Preliminary and Final DRAINAGE PLAN AND REPORT **ROCKY TOP MOTEL AND CAMPGROUND**

County File No.: PPR2140

EPC STORMWATER REVIEW COMMENTS
IN ORANGE BOXES WITH BLACK TEXT

SUBJECT: Drainage Plan and Report
Rocky Top Motel and Campground

EAST SFB DETAILS

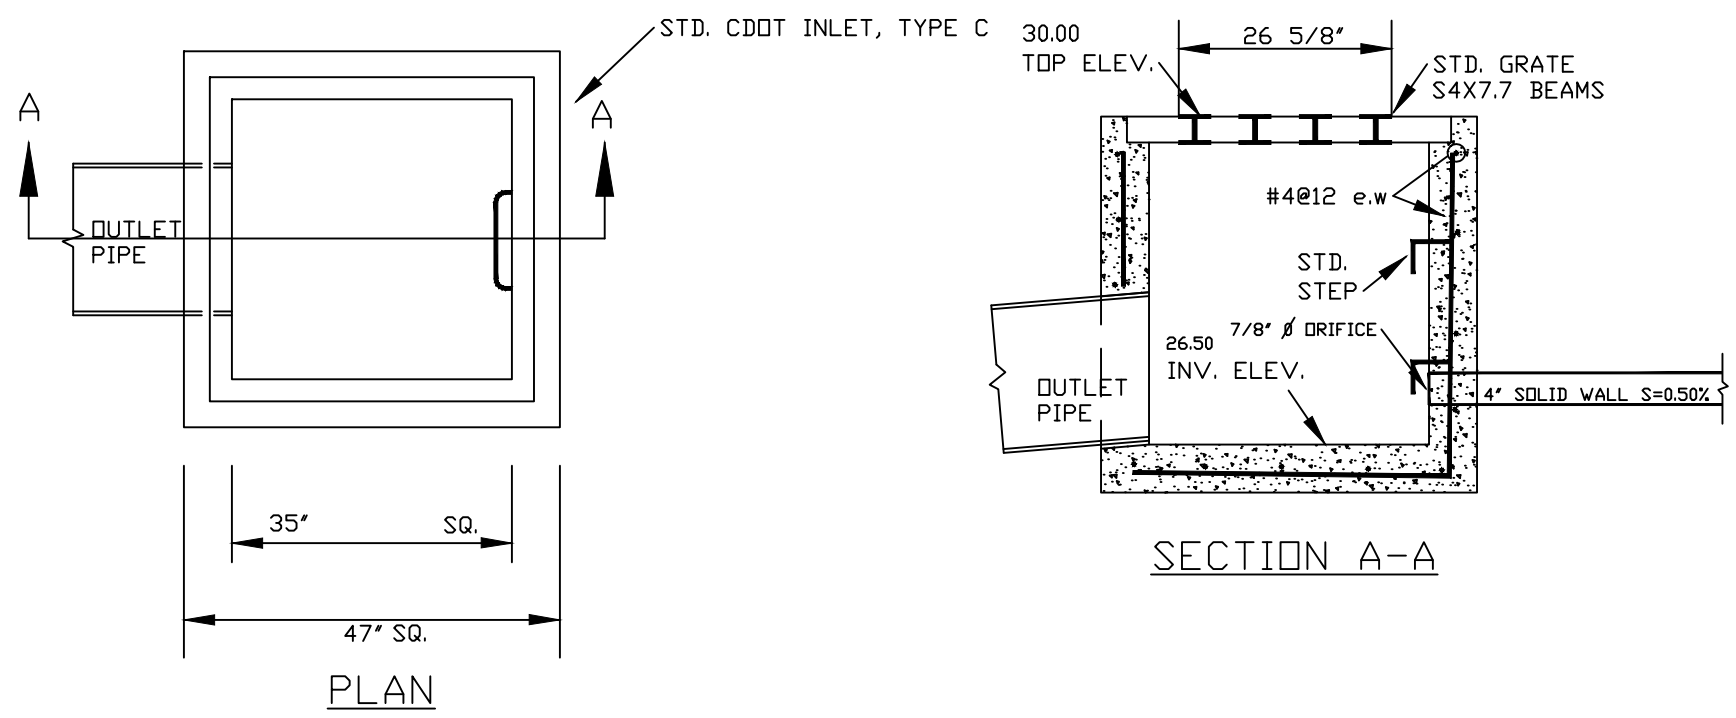
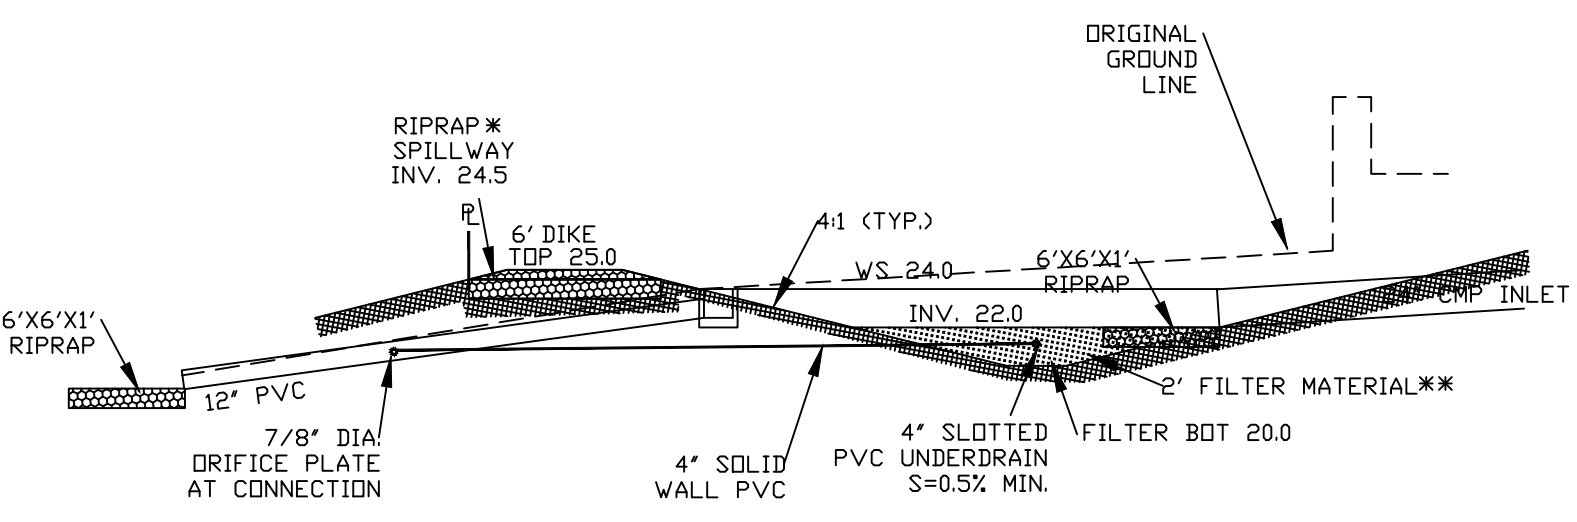
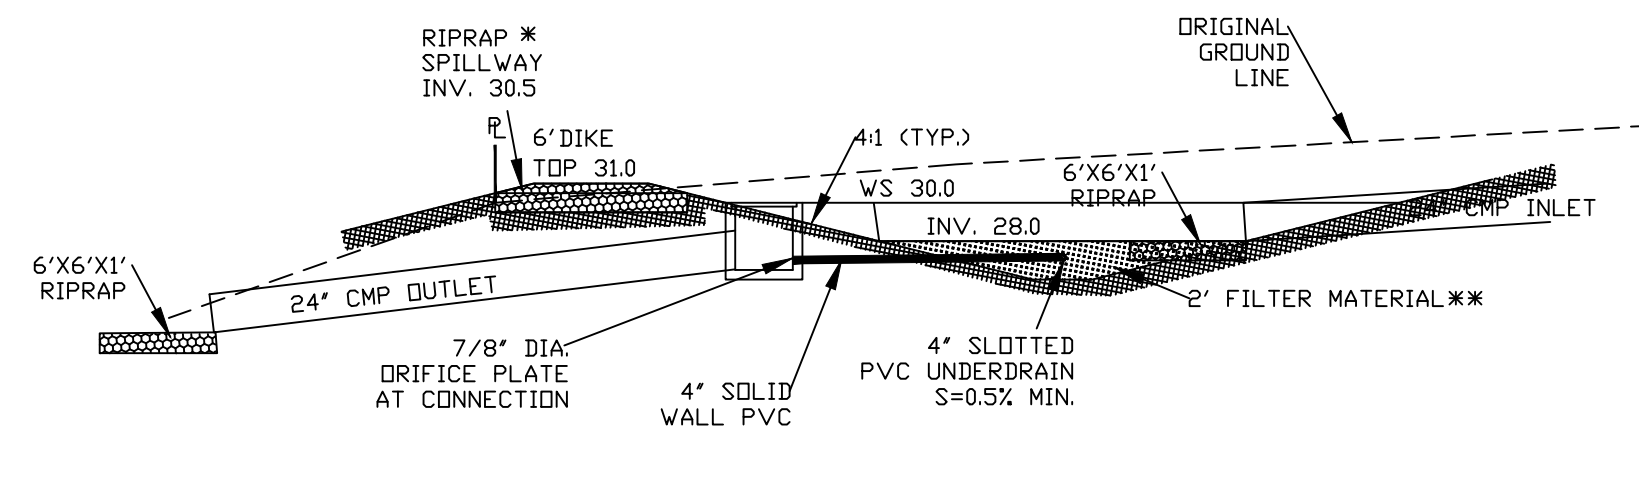
1.5ft here does not match what is shown on the plans. The plans show the bottom of the pond at 22ft elevation and inv of 4" pipe at connection to 18" pipe at 20.74ft. So something isn't right. Revise calcs and/or plans as needed to remove this discrepancy.

Cannot confirm whether or now 1.5ft here does matches what is shown on the plans. The plans show the bottom of the pond at 28ft elevation and inv of 4" pipe at connection to inlet box is unknown (not shown in plans). Revise calcs and/or plans as needed to clarify and to reflect this 1.5ft distance.

ALL TERRAIN RESPONSE: NOT ADDRESSED. SAND FILTERS NO LONGER PROPOSED.

ALL TERRAIN RESPONSE: NOT ADDRESSED. SAND FILTERS NO LONGER PROPOSED.
